Case Officer: Gemma Magnuson

Applicant: Mr & Mrs A Pasteur

Proposal: Discharge of conditions 3 (Opening Details and Material Samples), 4 (Method Statement) & 5 (Insulation Details) of 19/02110/LB

# CONSERVATION CASEMENT

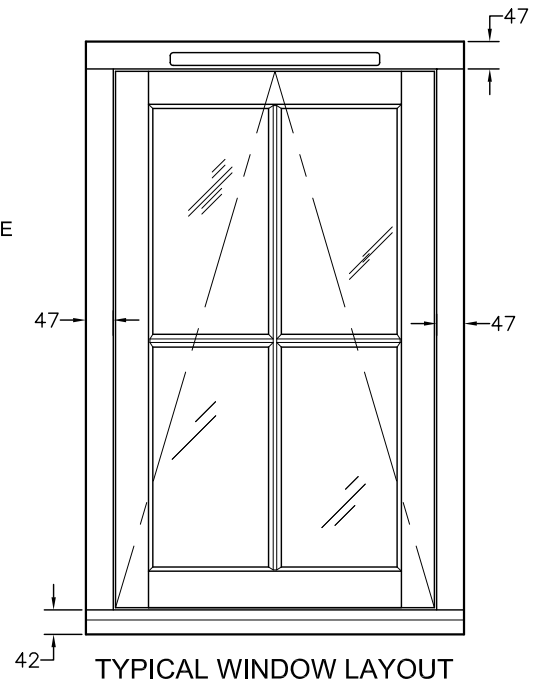
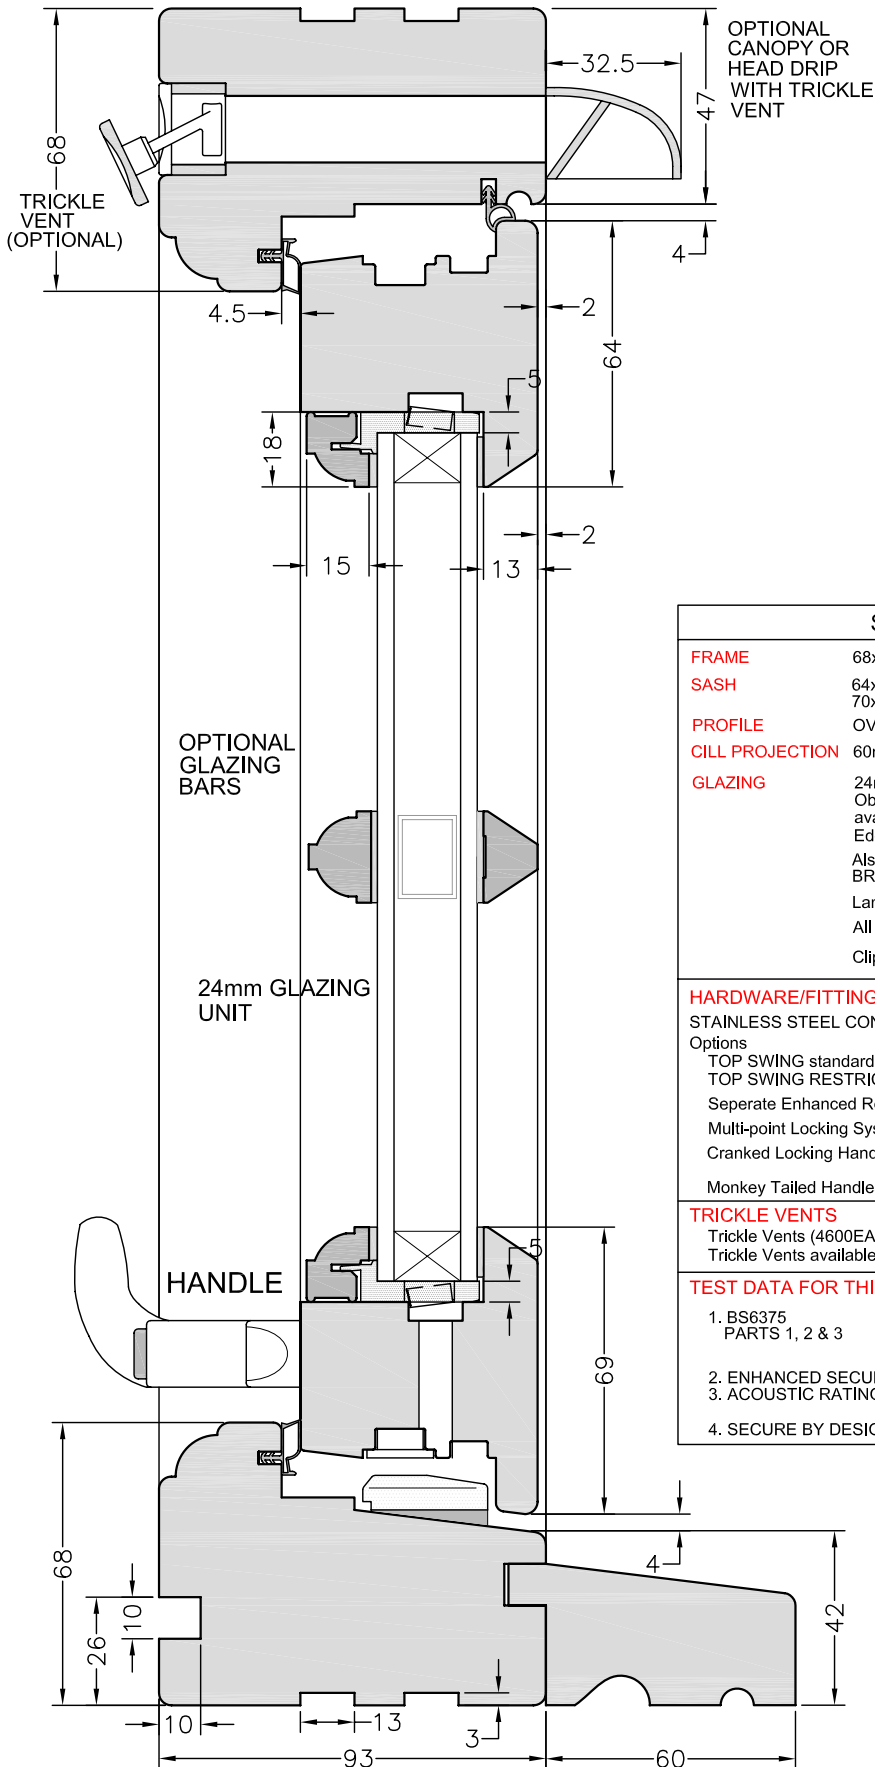
- 6.3. The current application followed the consideration of two DISC applications relating to openings (of the same type) within the extension (refs: 19/01418/DISC & 19/01419/DISC) and at this point, the Conservation Officer had already raised concerns regarding the use of standard double glazing with applied glazing bars.

- 6.4. I had raised these concerns with the Agent on 03 February 2020, advising that the openings should consist of slimlite double glazing with integral glazing bars.

- 6.6. I received comments from the Conservation Officer on 11 September 2020 advising that *"In my view although the windows on the extension aren't ideal and the Conservation Team would usually try to push for slimlite double glazing I am not sure that it is expedient to enforce those on the extension. The harm is more limited and reversible– (this is the second extension in this location since 2000) and the building is clearly read as a modern addition."*

- 6.7. No comment has been provided specifically with regard to the same openings being used within the outbuilding, although I have applied the same principle. The outbuilding is physically and visually detached from the main dwelling and continues to be read as a separate structure. The work is reversible, with the opportunity for more traditional and sympathetic openings to be installed in future without causing harm to the original fabric of the building.

- 6.8. It is very disappointing that the applicants had installed these openings prior to discharging conditions, however on balance, it is considered that we are unlikely to be able to defend the refusal of the application at Appeal for the above reasons. I therefore reluctantly recommend that this condition is discharged.

Openings in accordance with Mumford and Wood Ltd order details, and Conservation Casement details received with the application on 23 March 2020. Materials in accordance with Garden Office Method Statement dated 28 November 2019.
